Maryvale Solar Farm (SSD 8777) – EIS Exhibition

Thank you for your correspondence dated 20 March 2019 inviting Transport for NSW (TfNSW) comment on the subject State Significant Development Application (SSD 8777).

TAB A – Detailed Comments on State Significant Application SSD 8777

Figure 2-1 – Designated Heavy Vehicle route to project site

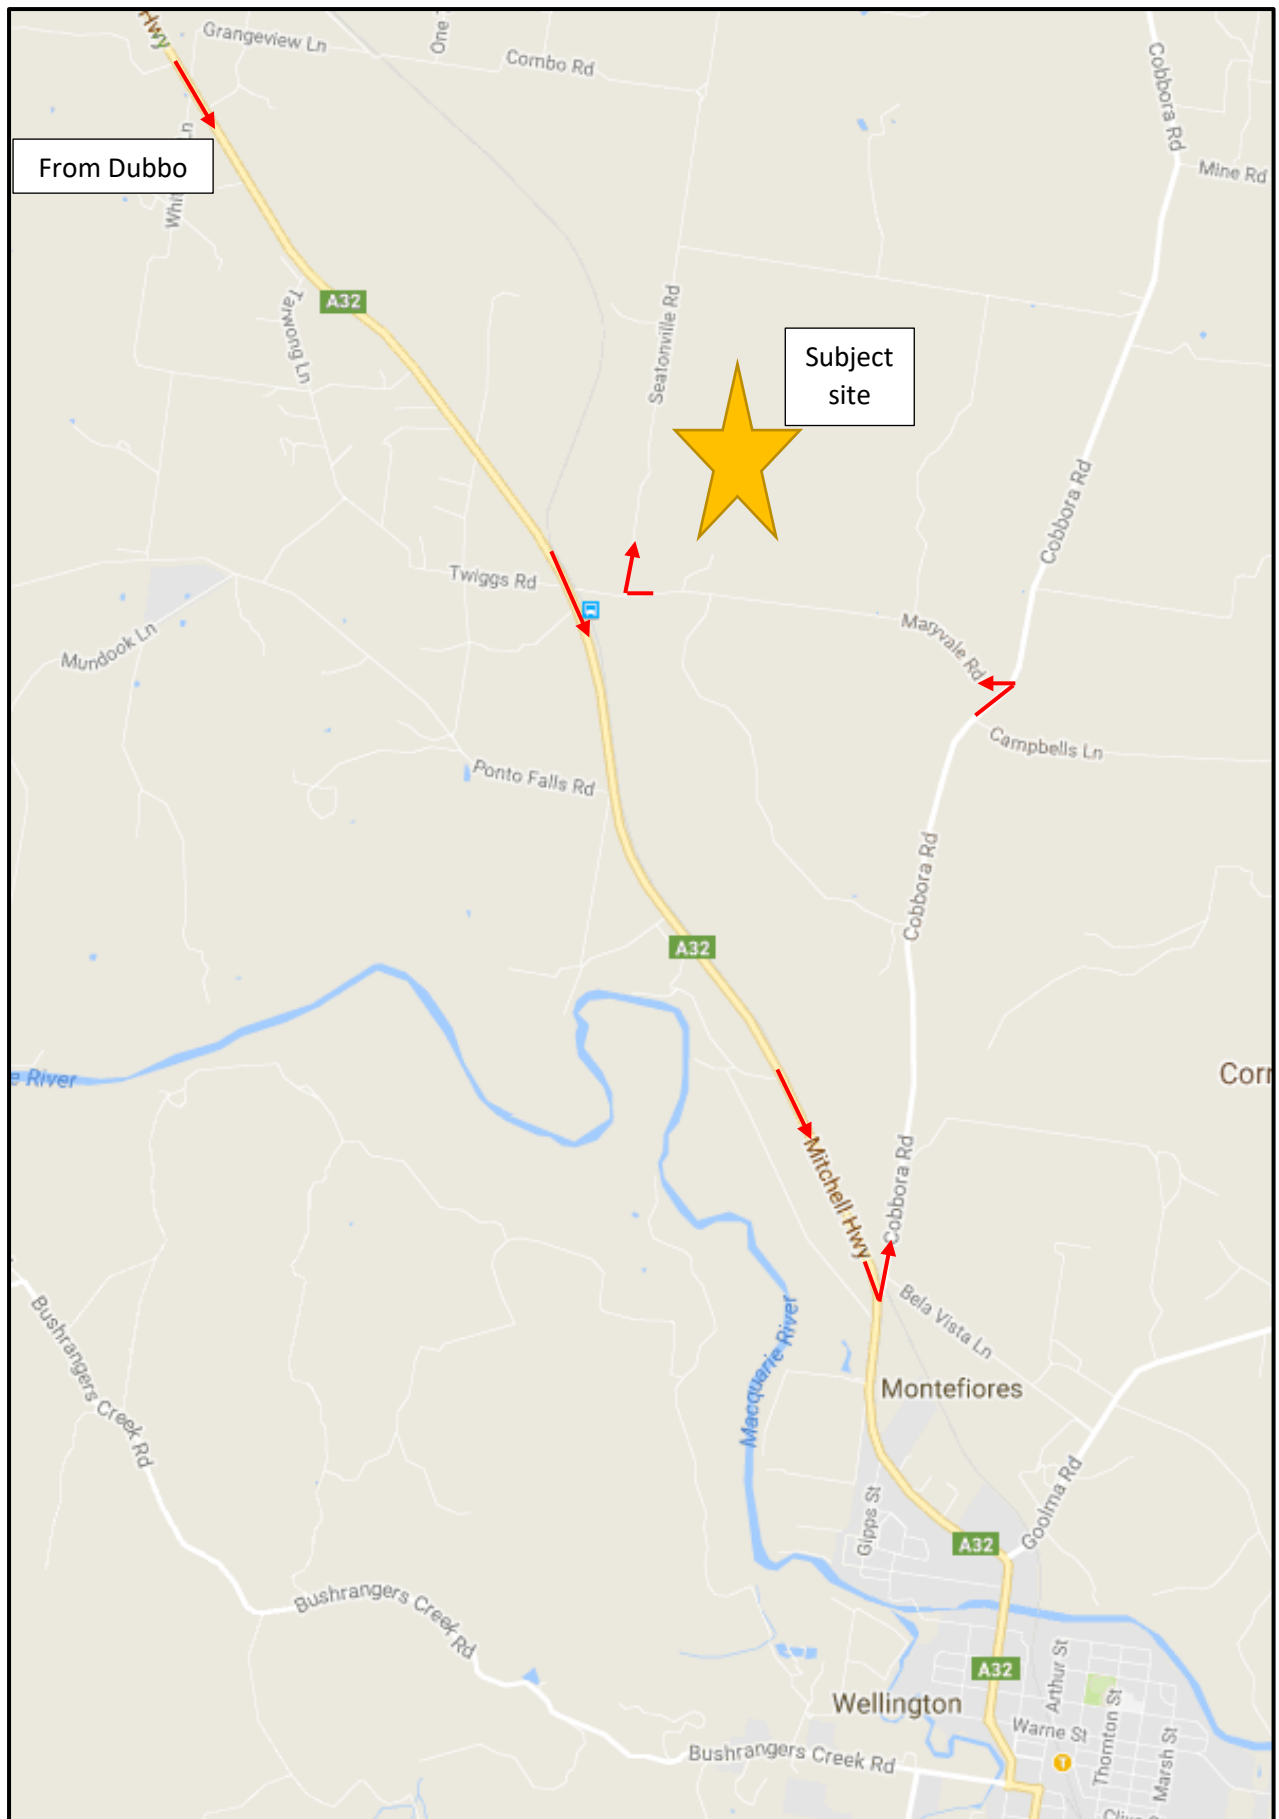
The Traffic Impact Assessment (TIA) states that the intersection of Maryvale Road and Mitchell Highway is considered unsuitable for use by traffic associated with the project site for entry or exit movements and further states that a passive level crossing located within 60 metres of Mitchell Highway will not be used.

In addition, the TIA includes the designated heavy vehicle route to the project site which may increase the use of an active level crossing at Cobbora Road.

The passive level crossing located within 60 metres of Mitchell Highway should not be used for the vehicles associated with the project as proposed by the Proponent.

Furthermore, the Proponent must prepare and provide JHR with an assessment based upon the Australian Level Crossing Assessment Model in order to identify key potential risks regarding the level crossing at Cobbora Road as a result of the increased use of the heavy machinery. In the event that such assessment finds that there will be significant increases in the use, the Proponent may be requested to upgrade to a grade separated crossing such as an overbridge and Dubbo Regional Council will also be requested to update the current Road Rail Interface Agreement to reflect the change to the level crossing in accordance with the Rail Safety National Law 2012.
